Application No: AB/75/20/PL
Site Address: 55-57 High Street Arundel BN18 9AJ
Description of works: Conversion of existing mixed use space to 1 No. 1- bedroom flat. This application affects the character & appearance of the Arundel Conservation Area & affects the setting of a Listed Building.

Thank you for your internet representation made on 25th July 2020 which has been recorded as an objection with the comments as follows:

## Proposed Ground Floor Plan

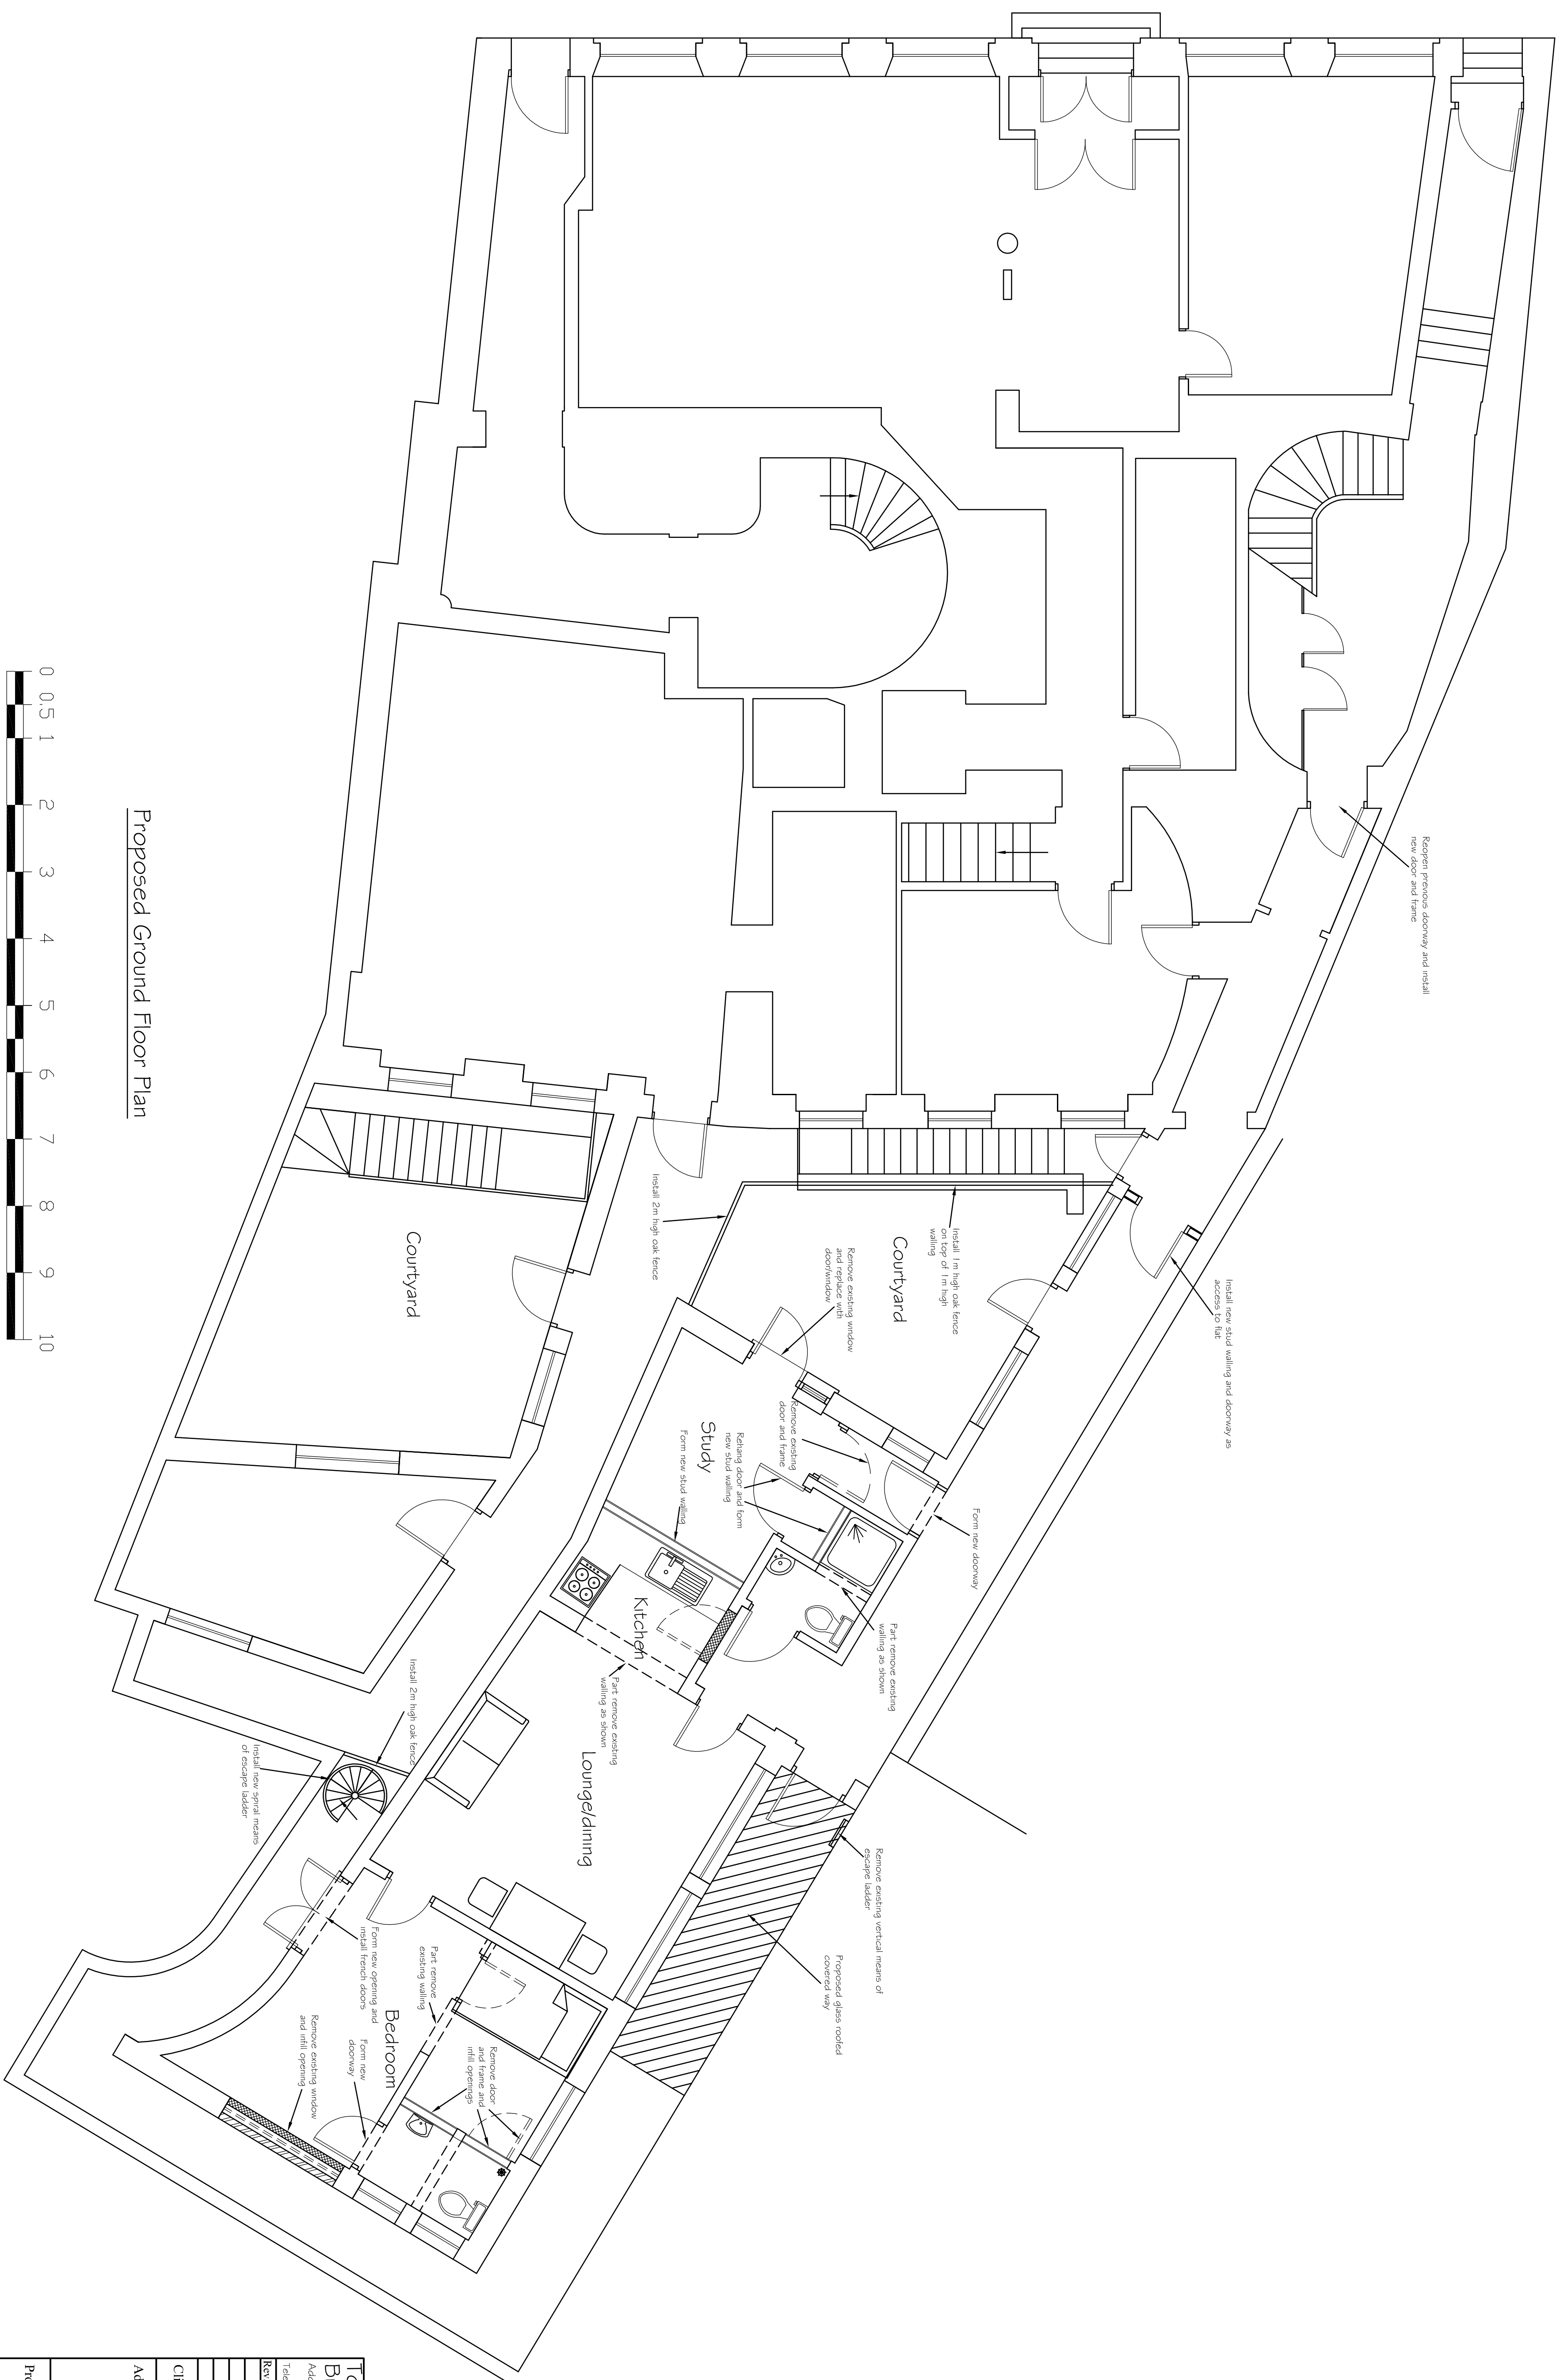
This is an observation and a request for appropriate action to be taken in the conversion, rather than an objection. Crown House abuts 55-57 High Street and the inter-connecting walls between it property and the adjoining properties are paper thin. The stairs of one of the neighbouring properties (I guess 55-57 High Street) protrude into this property and are neither encased nor sound-proofed; the regular movements on those stairs resonate loudly throughout this property's main living area and, to a lesser extent on the first floor. Such activities as talking, coughing, sneezing, hoovering, opening/closing doors and drawers cause a similar resonance. Although possibly not relevant to the Application, the point might also be made that the Twitten side of this property abuts a coffee bar with the coffee machine resting against the similarly paper thin wall; this means the banging part of the coffee making process (presumably emptying the used bean granules) resonates through the main living area of this house. In view of the foregoing it is requested that sound proofing iaw with extant Regulations is installed.
